AW-40-12 – 25 Kingsway – OBJECTION 18-3-2012

Head of Planning Services
Arun District Council
Maltravers Road
Littlehampton
BN17 5LF

OBJECTION to AW/40/12 – 25 Kingsway – Alteration to front elevation

proposed roof plan

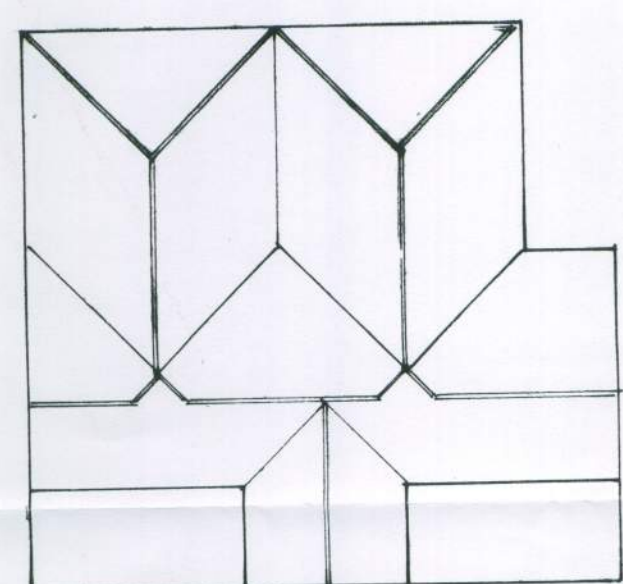
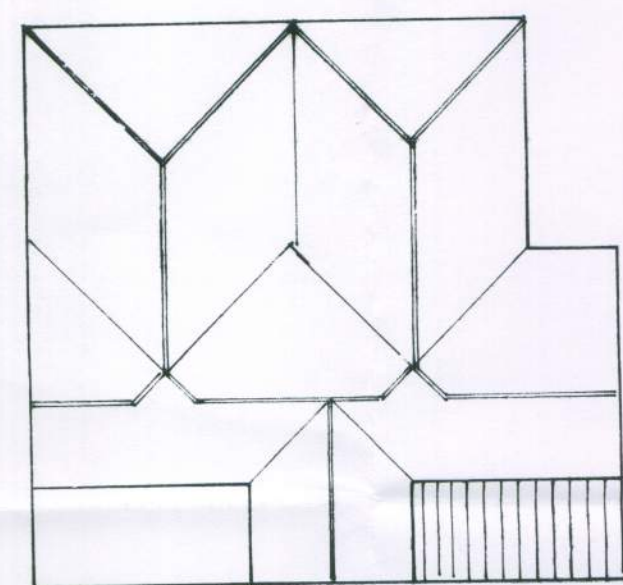
7. We are not persuaded that stripping the existing roof and replacing it with grey Redland mini-Stonewolds would contribute anything towards preserving or enhancing the character of the CHCA or making a positive contribution to the environment.

sheet 2 of 2

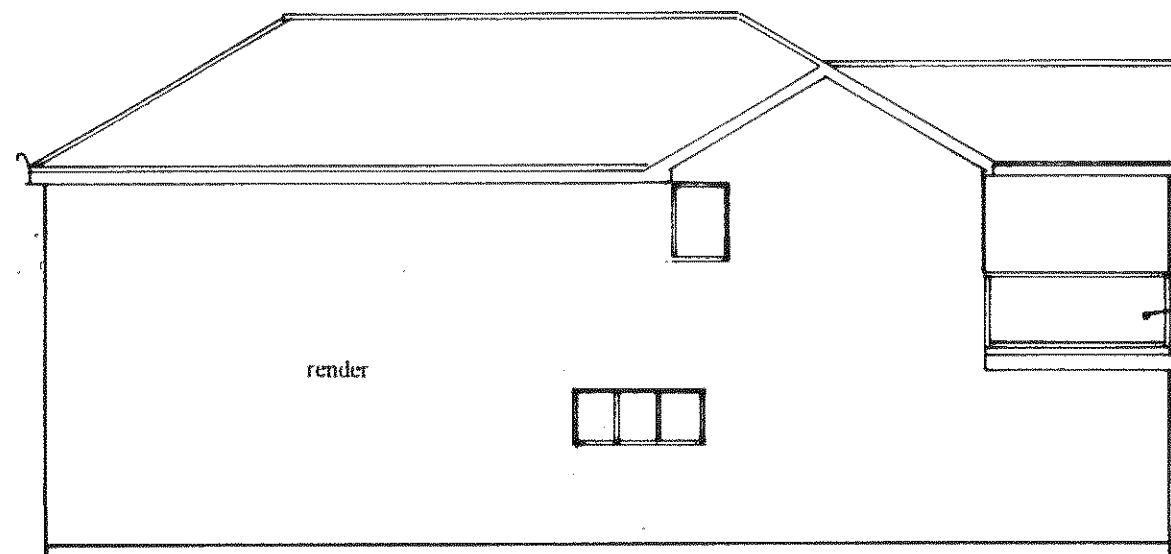
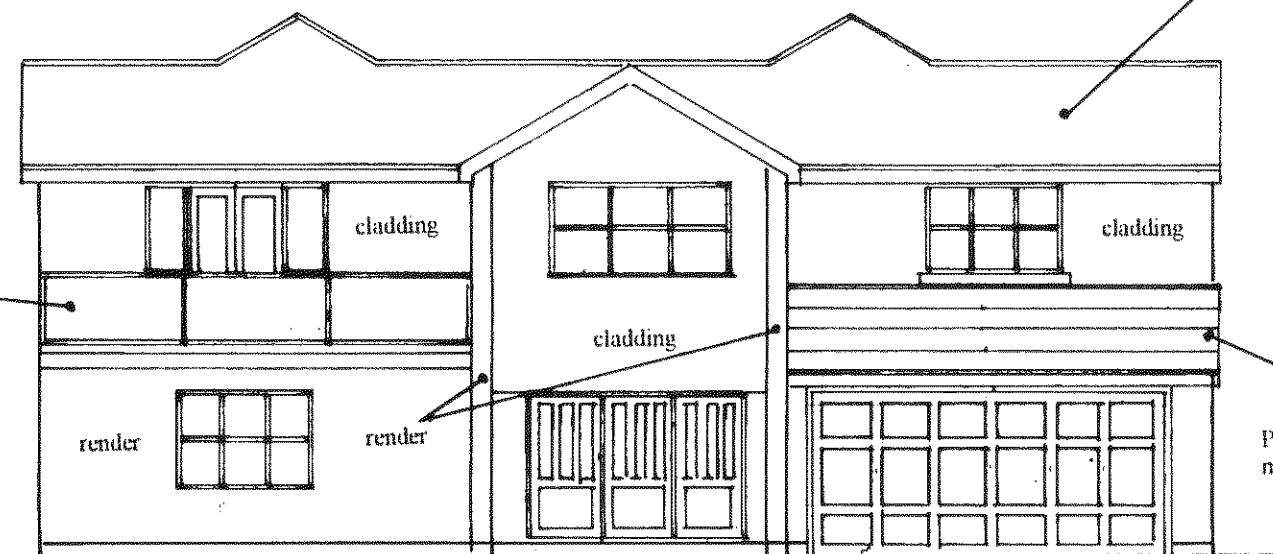
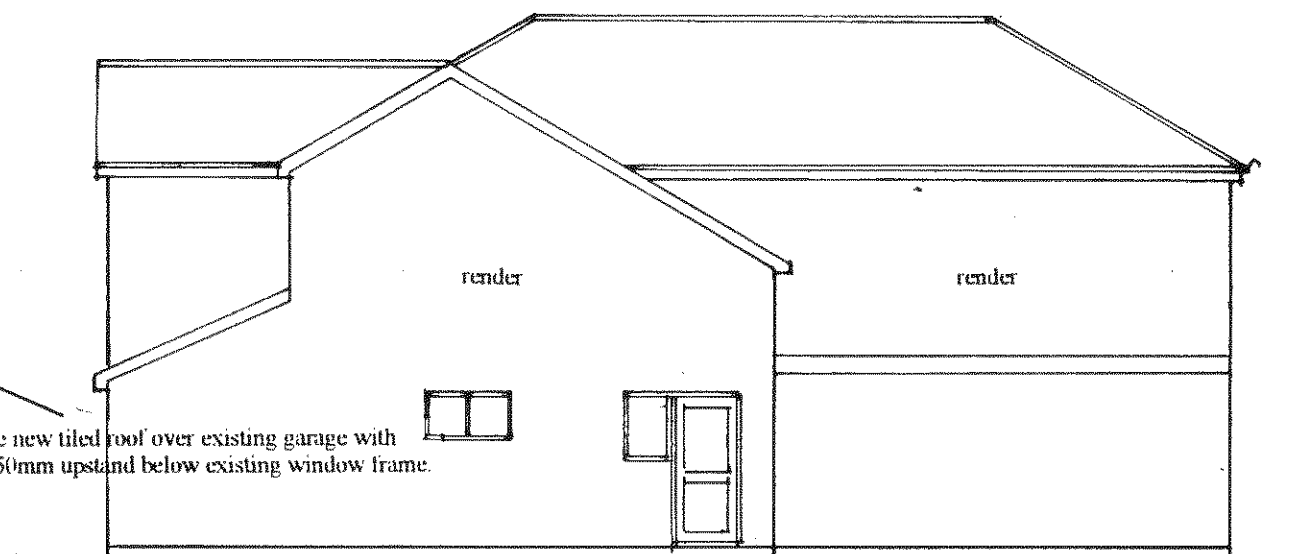
6. The applicant gives more detail regarding his proposed ‘*external, materials alterations*’ (para. 3 on the Form) on the ‘Proposed External Alterations’ plan (2 of 2) than he does in the D&AS by annotating this ‘*Remove existing concrete interlocking roof tiles and replace with Redland mini-Stonewolds*’. CHECAA feels that the existing roof – with decades of life left in it and certainly not in need of replacement – is pleasing and that it blends well with the house and houses surrounding it.

8. We find the application to be sadly lacking in detail and consider it to be totally unacceptable for the applicant to state only ‘*and external materials alterations*’ when this embraces, inter alia, the complete roof strip and re-tiling – without giving any indication of how this will benefit the house or the conservation area. We say the proposed roof will have an incongruous impact among the existing roofs of adjacent properties and photographs are attached for consideration.

3. CHECAA cannot accept that the external cladding and colourwash rendering of the existing aesthetically pleasing, attractive and tasteful light brickwork will in any way serve to preserve or enhance the area. On the contrary, we consider that it will stick out like a sore thumb – not in a ‘wow’ factor way but a ‘yuk, *what a mess that house is – what a blot on the landscape*’ style - and that is not CHCA!

4. It is true to say that there is a painted panel on the house next to the site (No.27) but equally true to say that CHECAA considers this, built and painted long before CA designation, to be a displeasing feature which does not enhance the area. It certainly is not regarded as constituting a precedent for the acceptance of rendering brickwork in this part of the CHCA.

5. It is not accepted, as stated in the D&AS, ‘*complimentary (sic) with its seaside location*’ for it is not, per se, ‘seaside’ as it would be in The Drive where the practise of painting was adopted by the initial Architects, Joshua Auty and Glanfield in the 1930’s. And at No.25 it complements nothing at all – the proposals would be tawdry and damaging to the street scene and area.
